Approval of details reserved by condition imposed under FG/69/16/OUT
(APP/C3810/W/17/3166634) relating to condition 6-proposed traffic light system.

Paddock House 44 Ferringham Lane Ferromg

Thank you for your internet representation made on 11th April 2018 which has been recorded as **'an objection'** with the comments as follows:

Project: 44 Ferringham Lane
 New Road Design

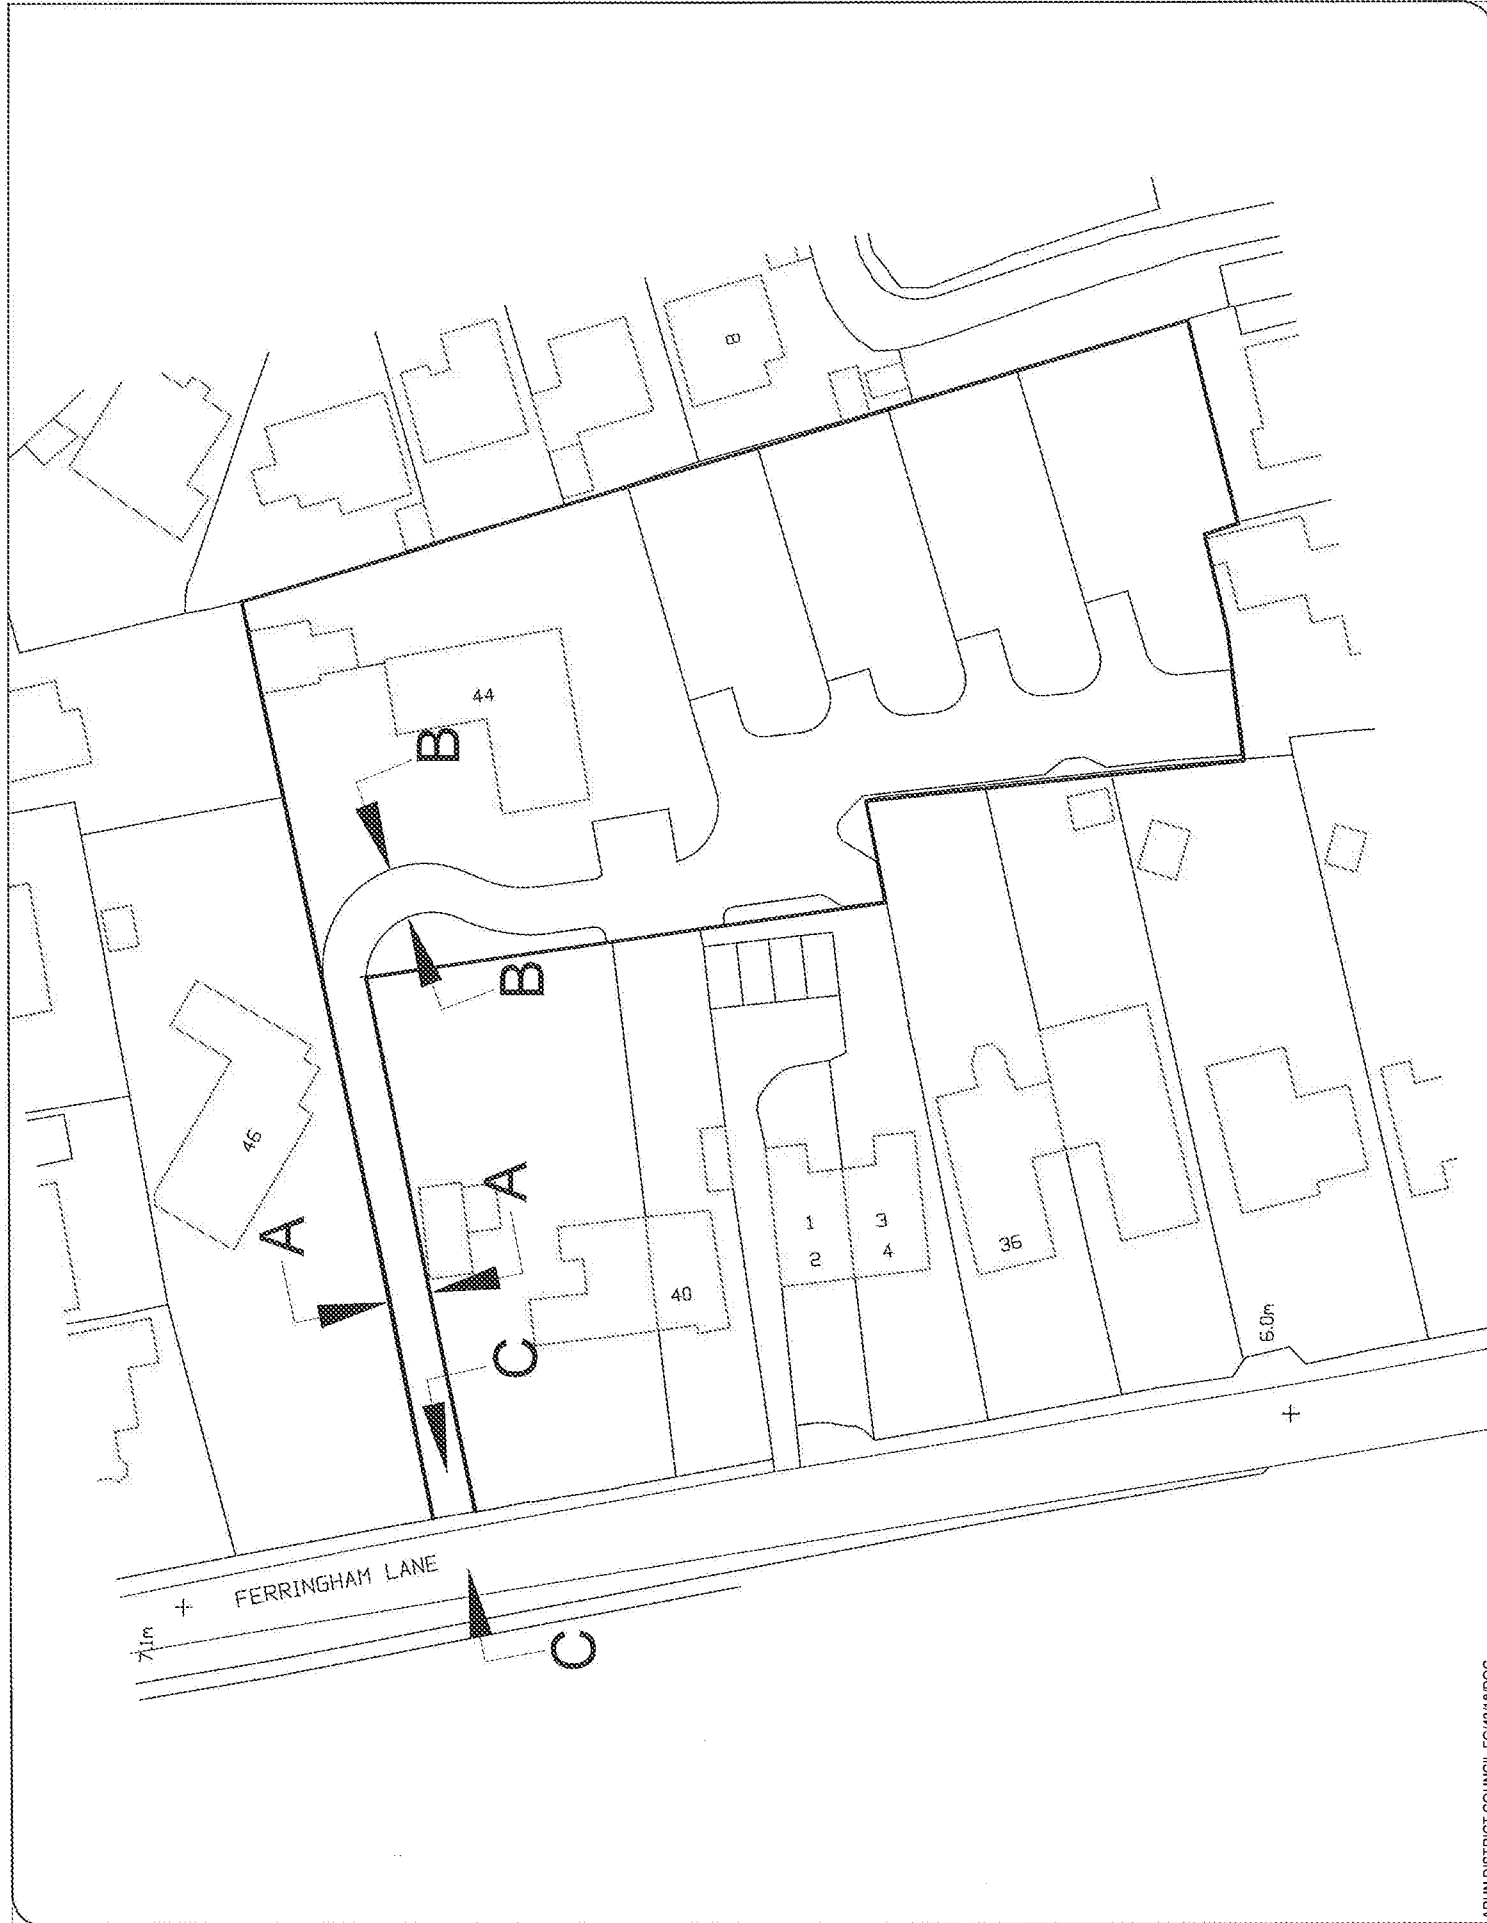
Ferring Conservation Group objects to the application to discharge Condition 5 in the allowed appeal: 'No development shall take place until the 4 m wide shared surface access has been constructed in accordance with the approved plans'. This condition requires the actual construction of the access way, not just the submission of drawings and specifications.

Th Transport Consultants say in para 3, 'The maximum access width under the control of our client is four metres, however there is a dispute with the owner of the adjacent property as, we understand, that a boundary fence has been erected on land that is under our client's control'.

That dispute must surely be resolved in the applicant's favour before he can begin constructing a resurfaced access road, and before that Condition can be discharged. There is also the matter of the related Condition 7, that requires visibility splays at the access of 2m x 43cms to the south and 2m x 39cms to the north. These areas are clearly not under the applicant's control, and would require the agreement of the owners of the two adjacent properties. This is not likely to be agreed.
